RE: Amendments to planning application Ref: Y/98/18/RES

Please find below a list of the amendments we would like to make on planning application Ref: Y/98/18/RES.

Drawing no: 18.1330.606 Rev: C3

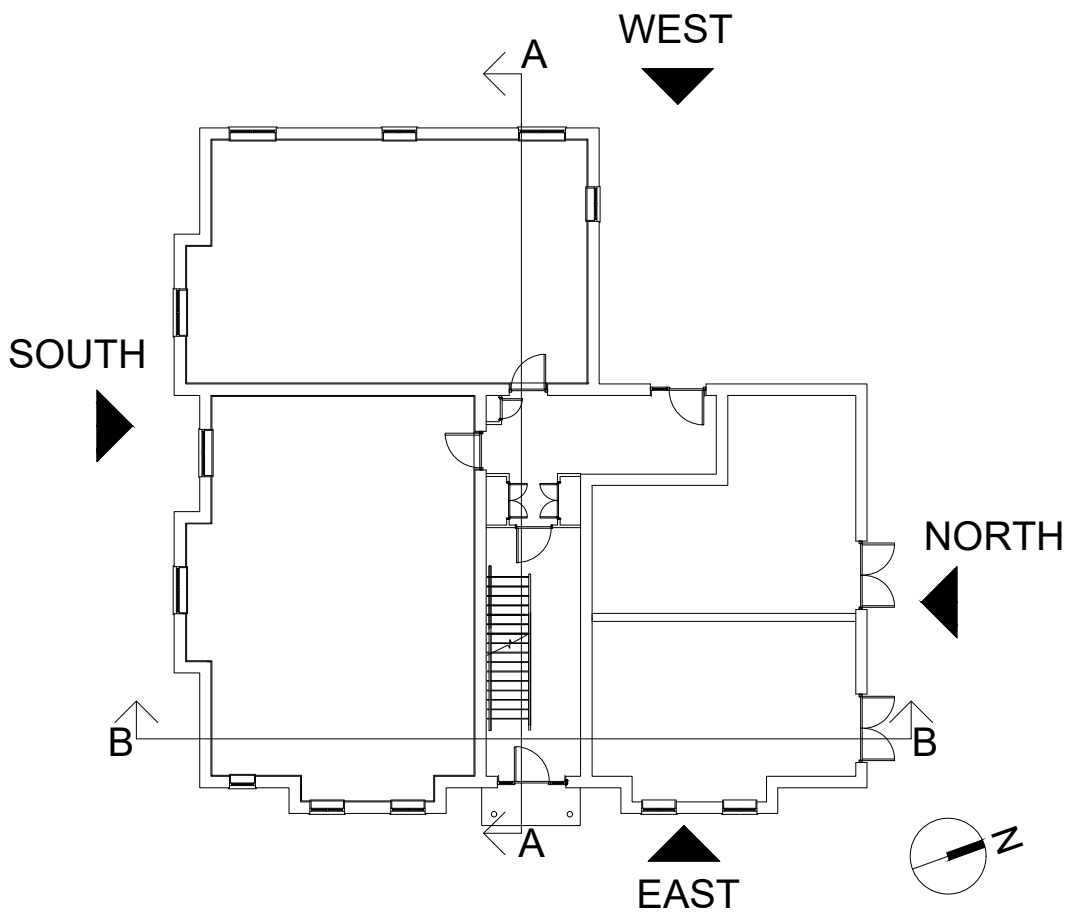
- The OV has changed from two units to one larger unit. Shown on the east elevation of drawing 18.1330.606 in the roof space.
- Apartment changes for 67-74 on the south side of elevation drawing 18.1330.706. The window configuration has changed to suit the revised kitchen layout internally. It did not meet the minimum required volume capacity set out in the HQI standards at the planning stage.

Drawing no: **18.1330.704** Rev: **C3**

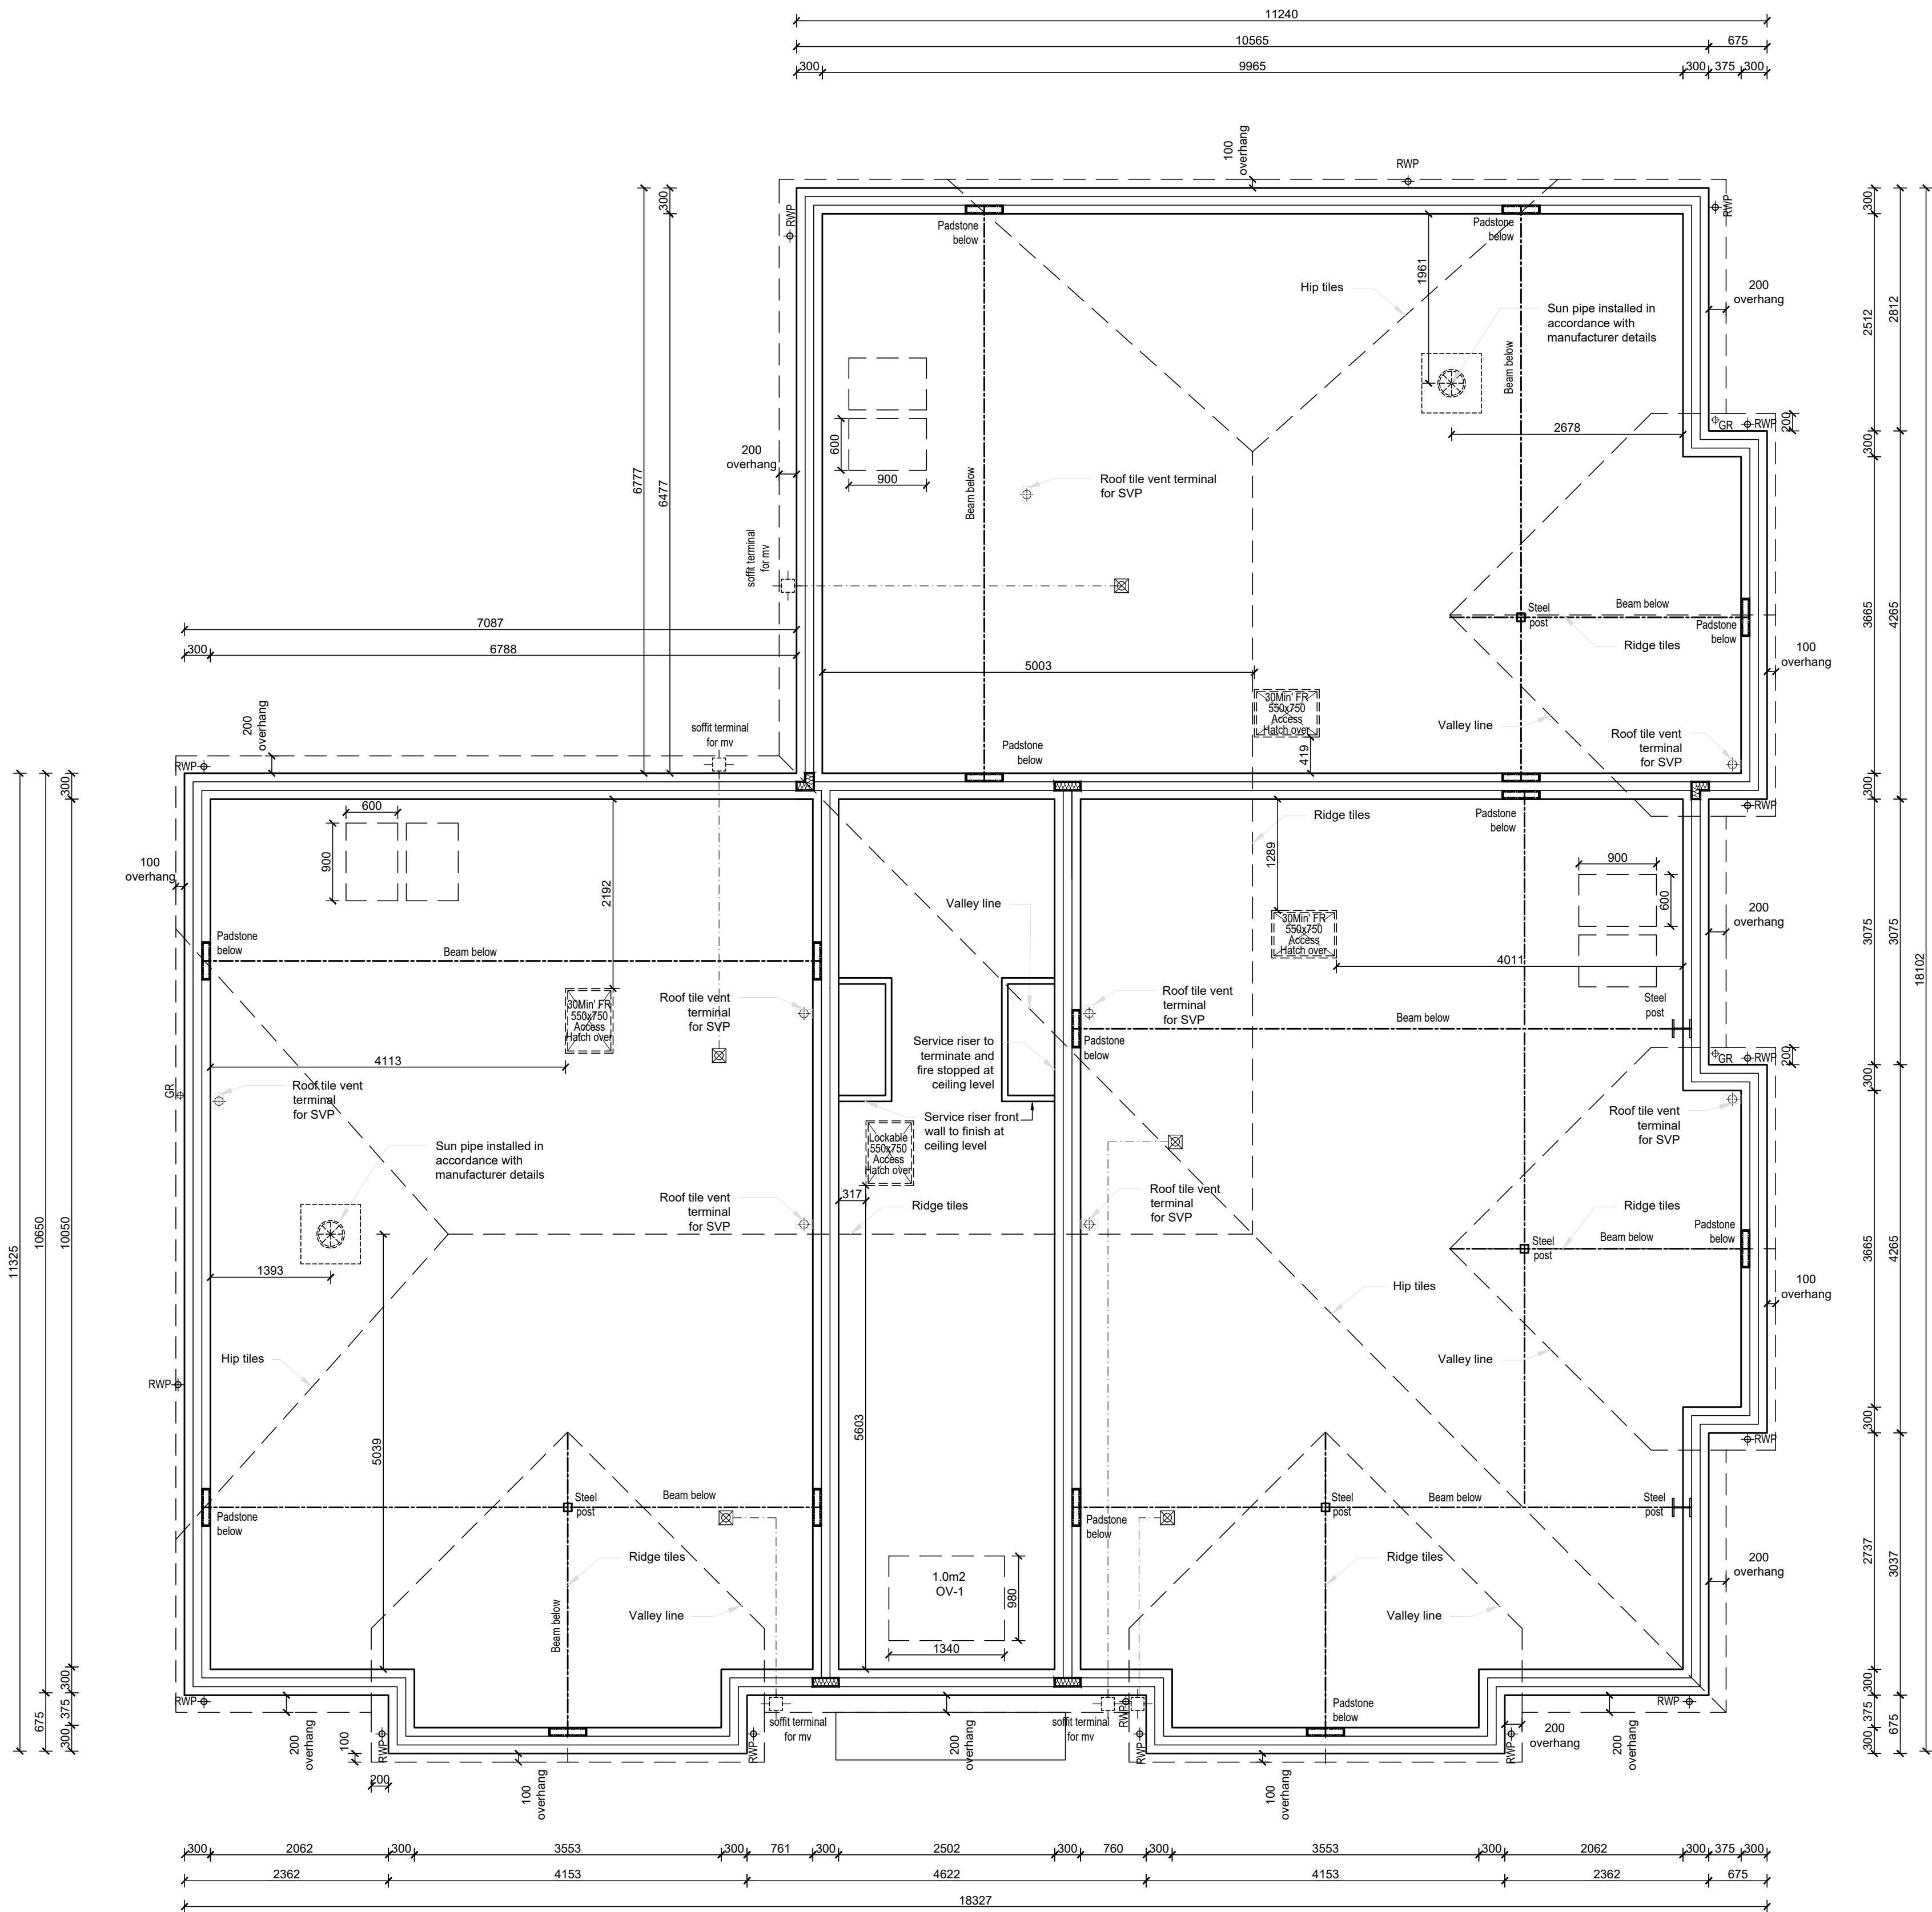
- Sun Tubes added for plots 62,63,73,72
